SSD-9472 Sikh Grammar School
Lots 42 & 43 DP30186 151-161 Tallawong Road Rouse Hill

The following forms our submission regarding the above Development Application for a proposed school. We are making a submission on behalf of the adjoining site to the north at 141 Tallawong Road Rouse Hill (Riverstone Dev Pty Ltd).

DRAWING TITLE				
EARTHWORKS GRADING PLAN (STAGE 1)				
PROJECT NO.	PLANSET NO.	RELEASE NO.	DRAWING NO.	REVISION
P1806439	PS05	R06	PS05-C100	E

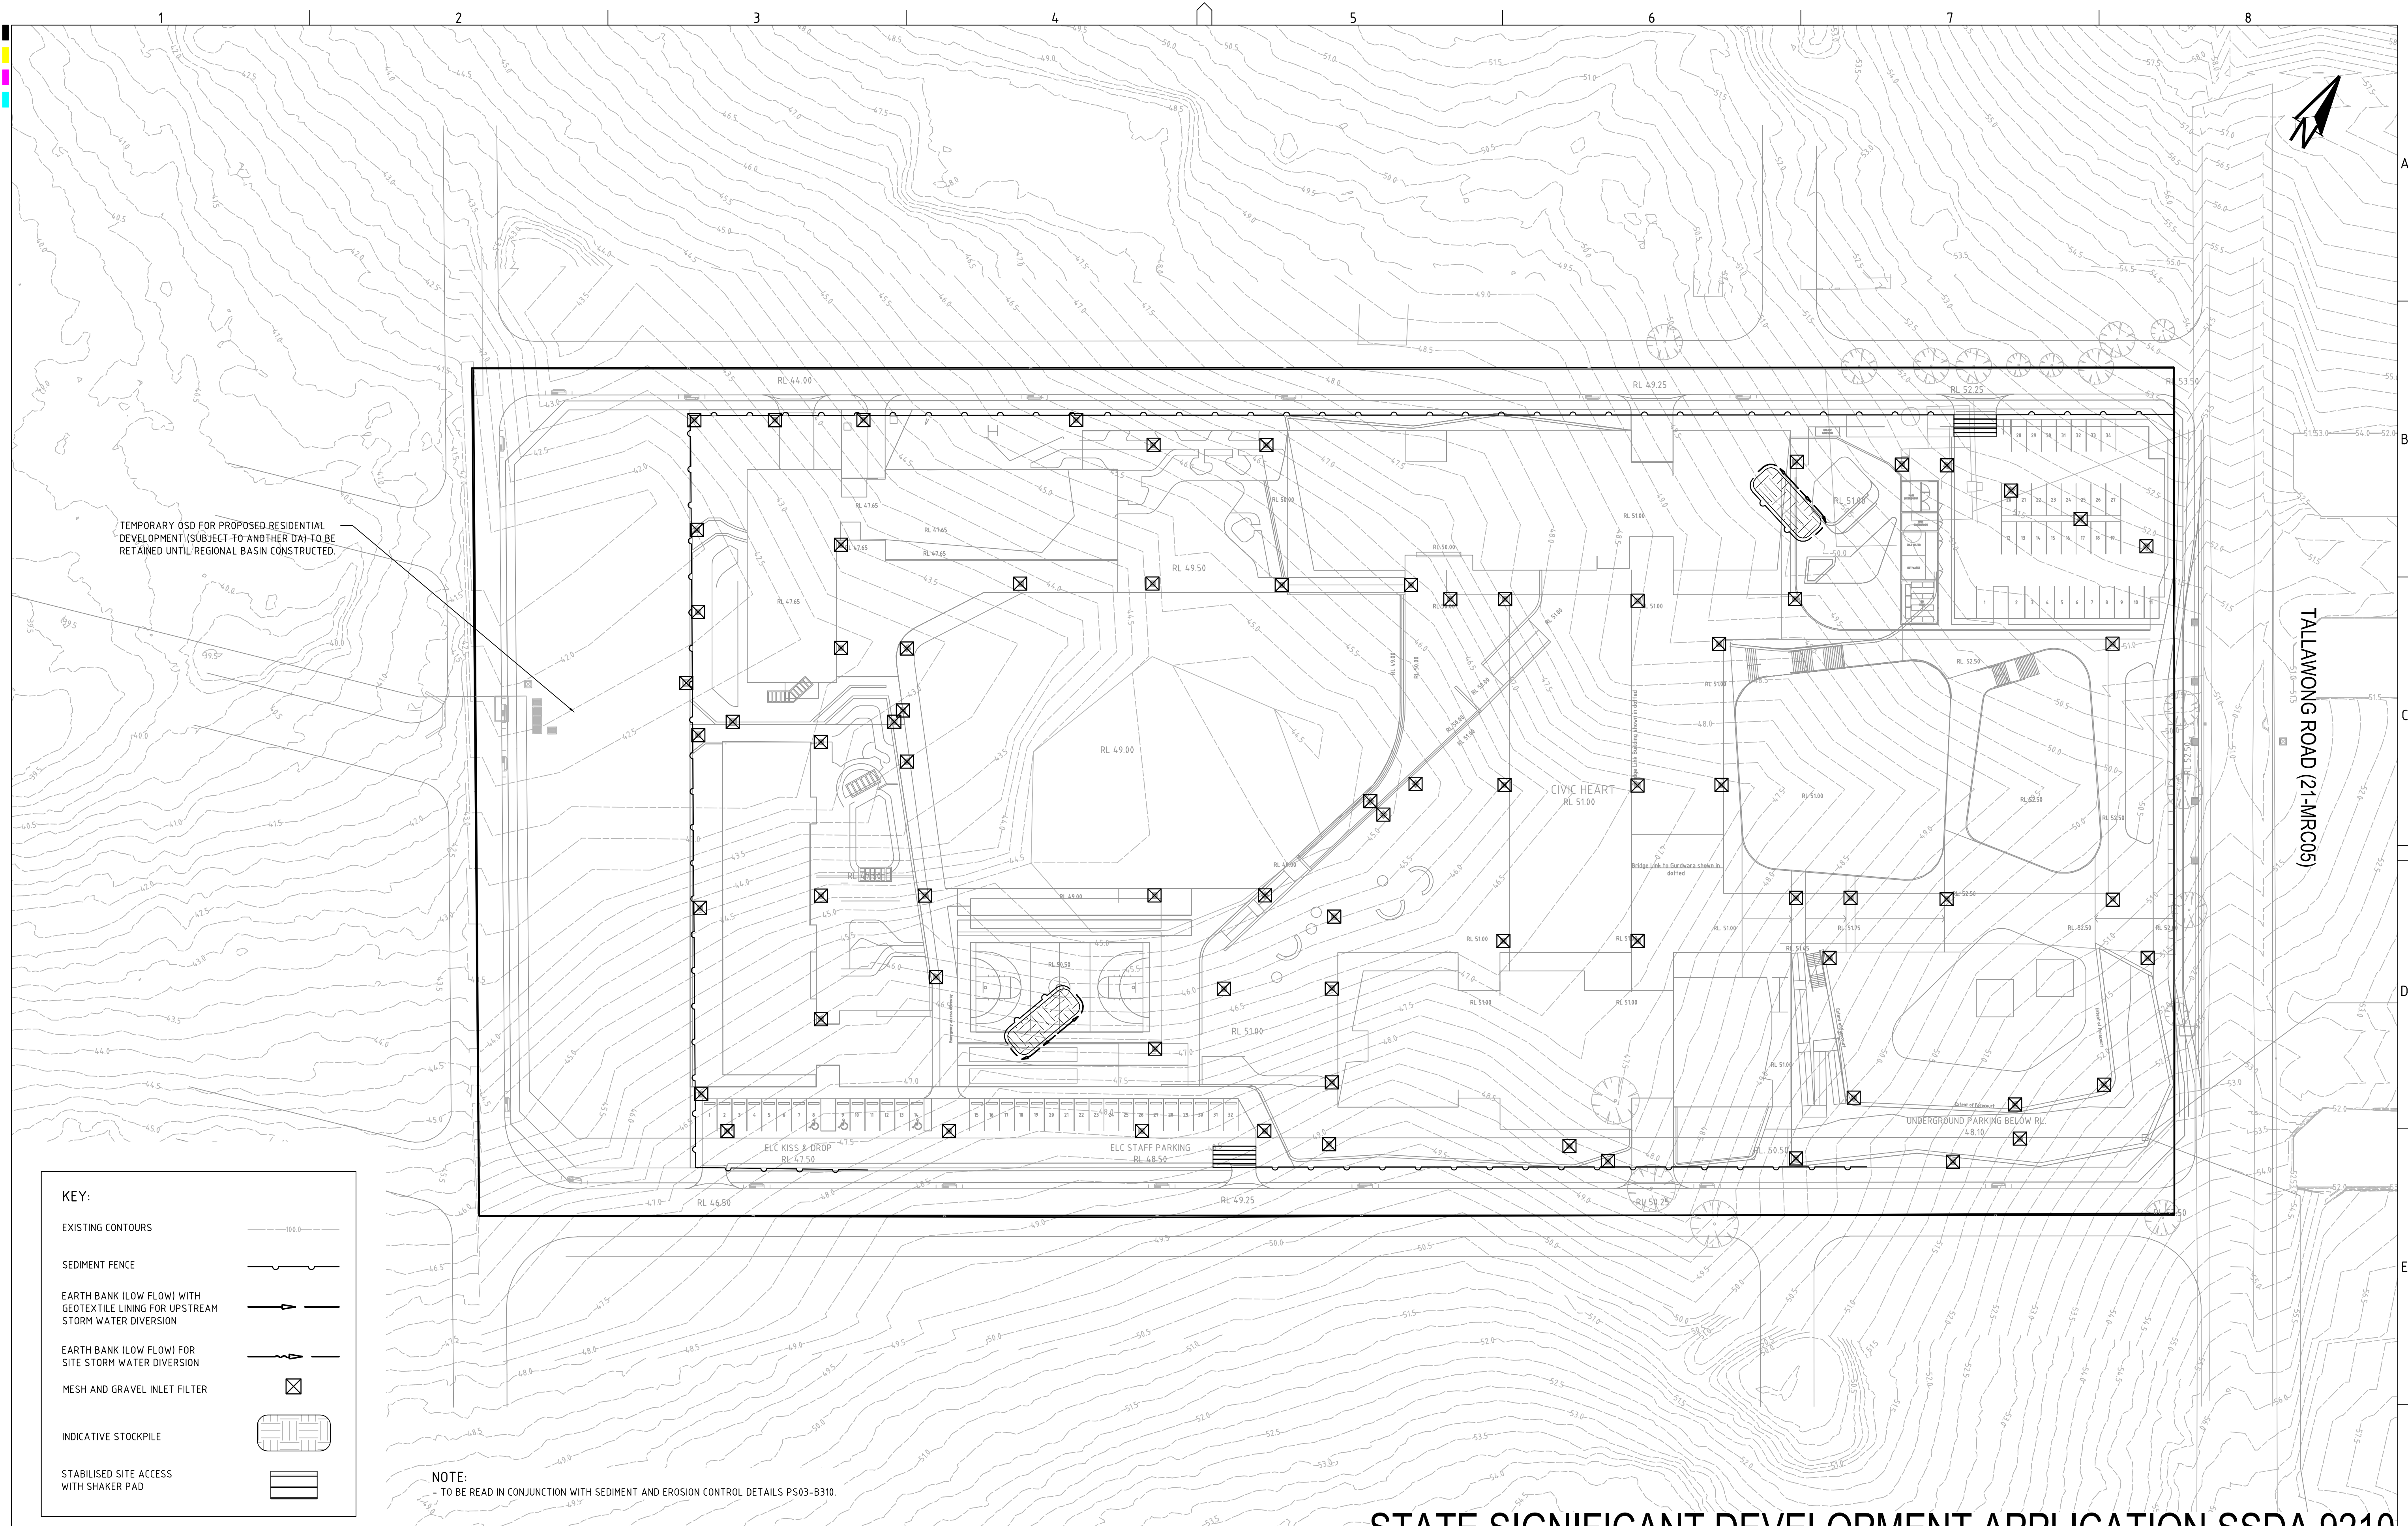
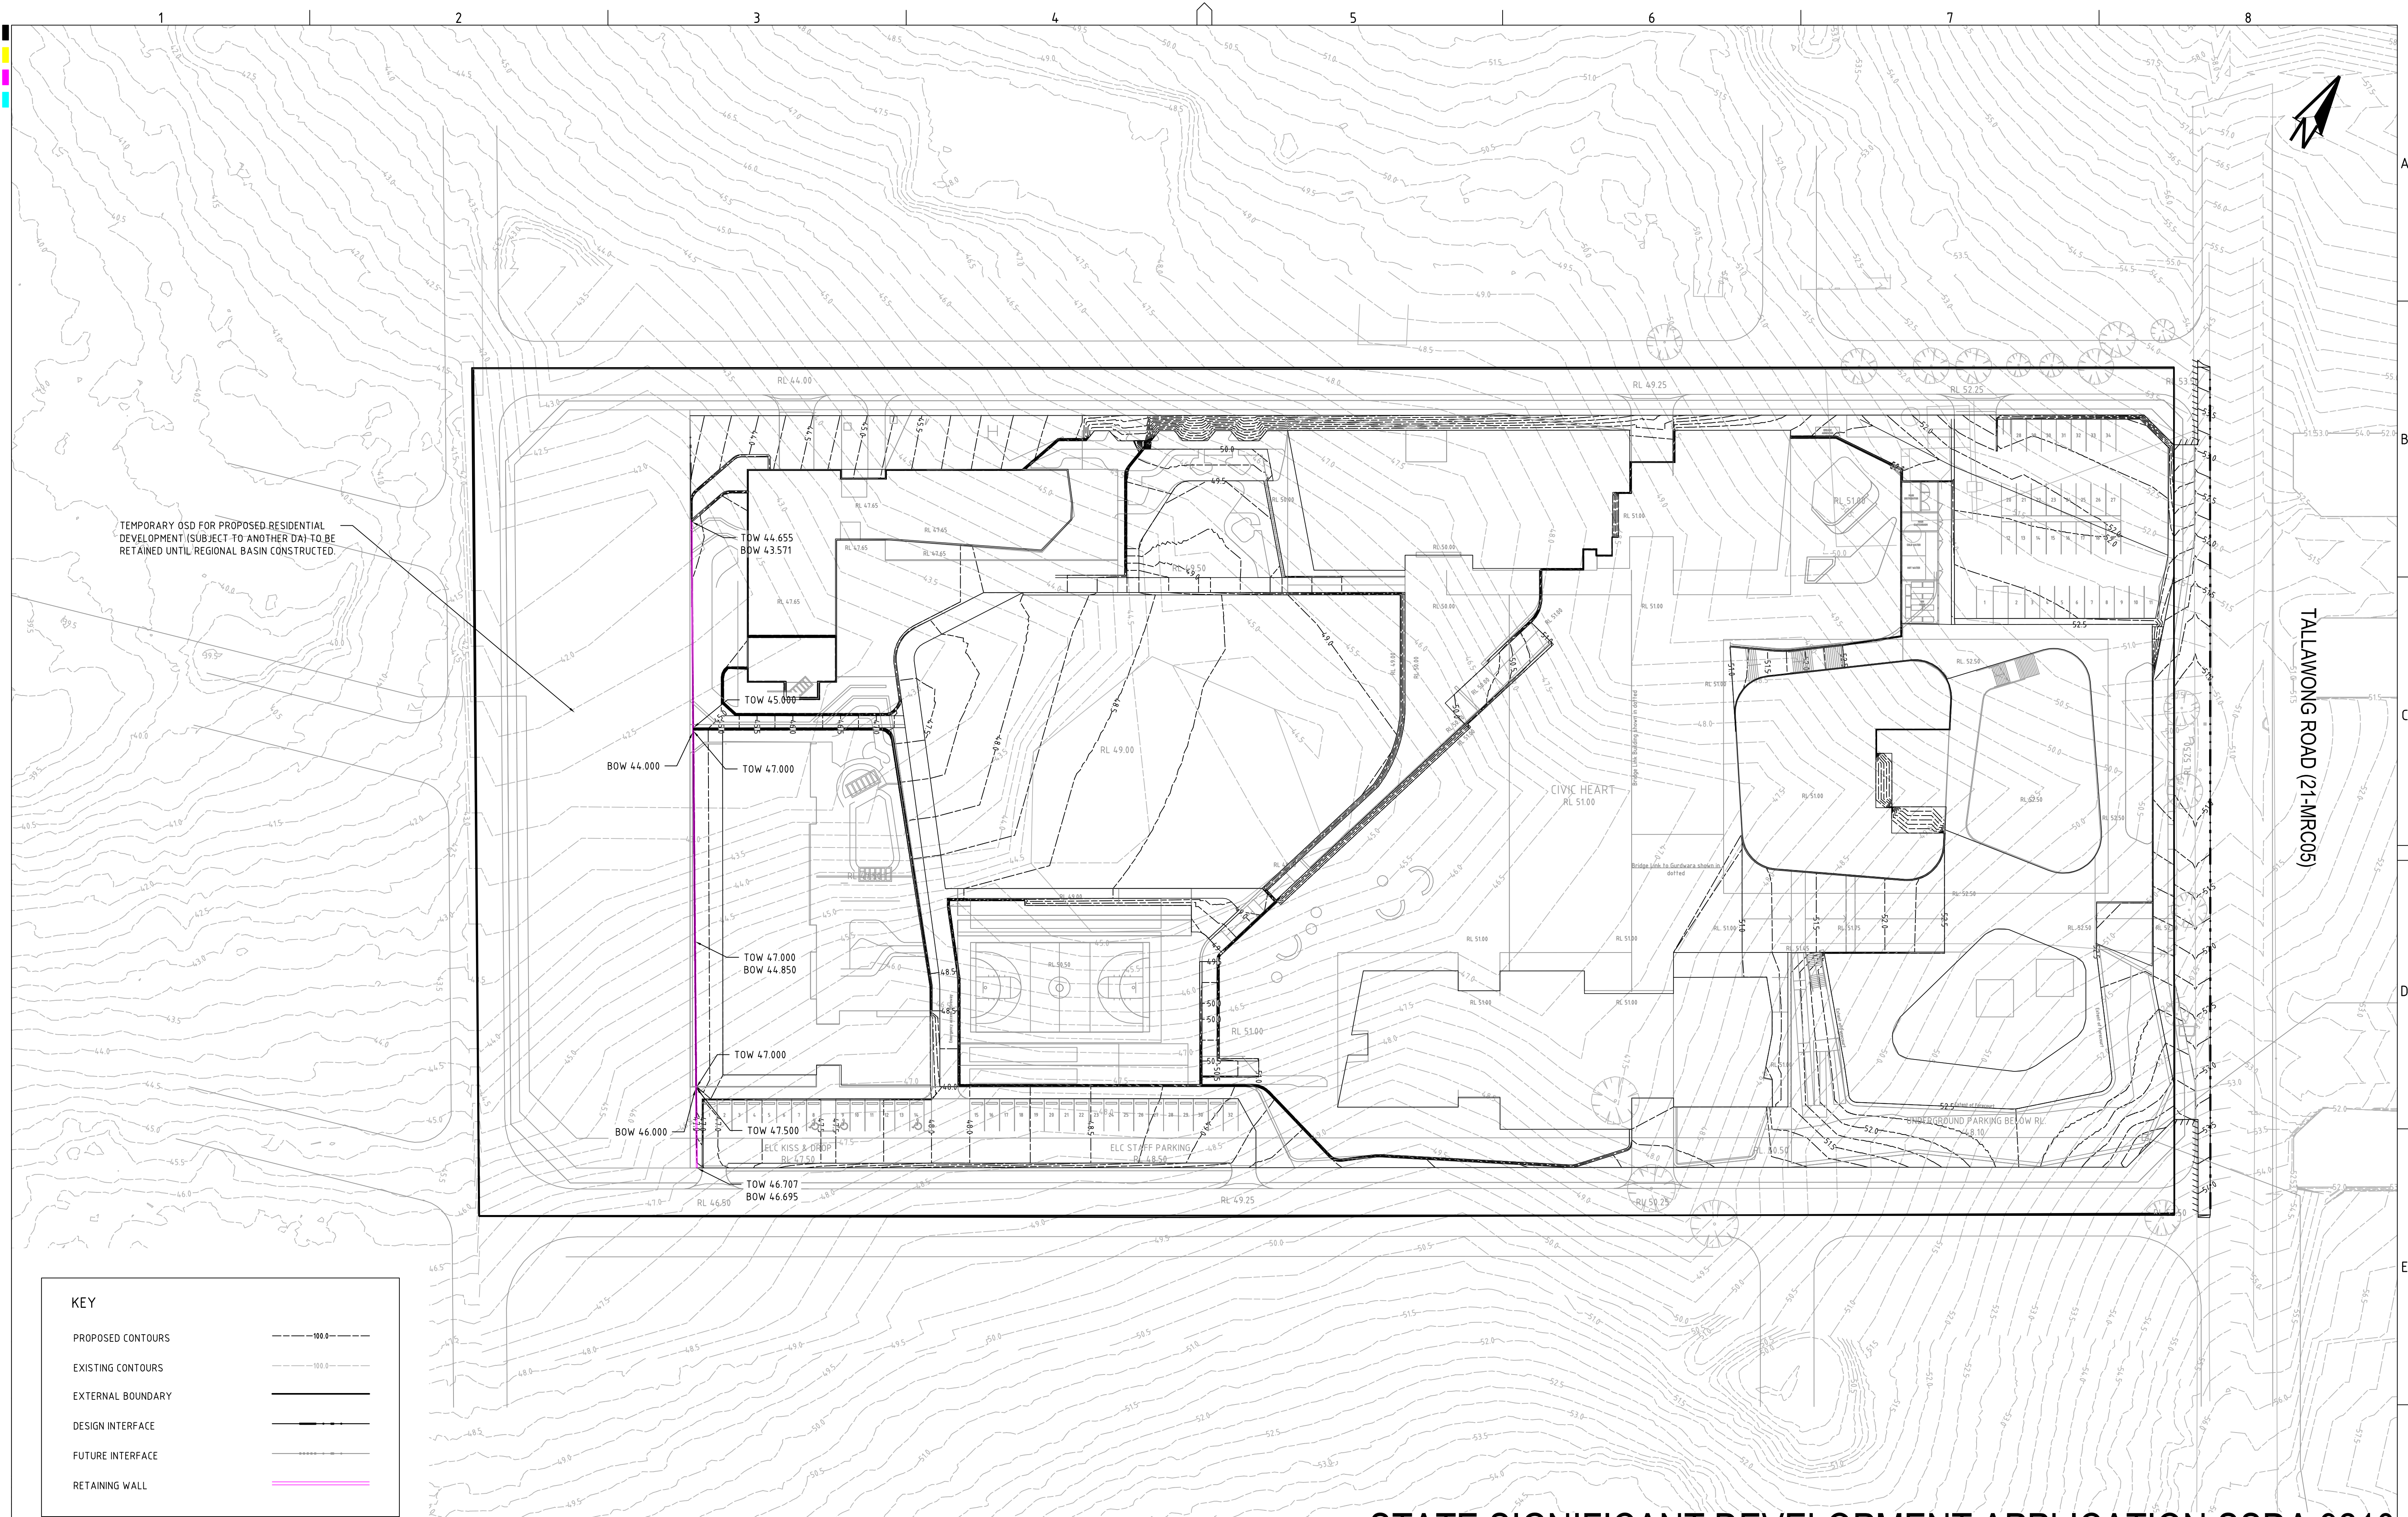
The engineering drawings indicate that there is battering to the adjoining properties to the north, south and west. We have not granted consent for any works to our property (141 Tallawong Road) and therefore the application cannot be approved in its current form.
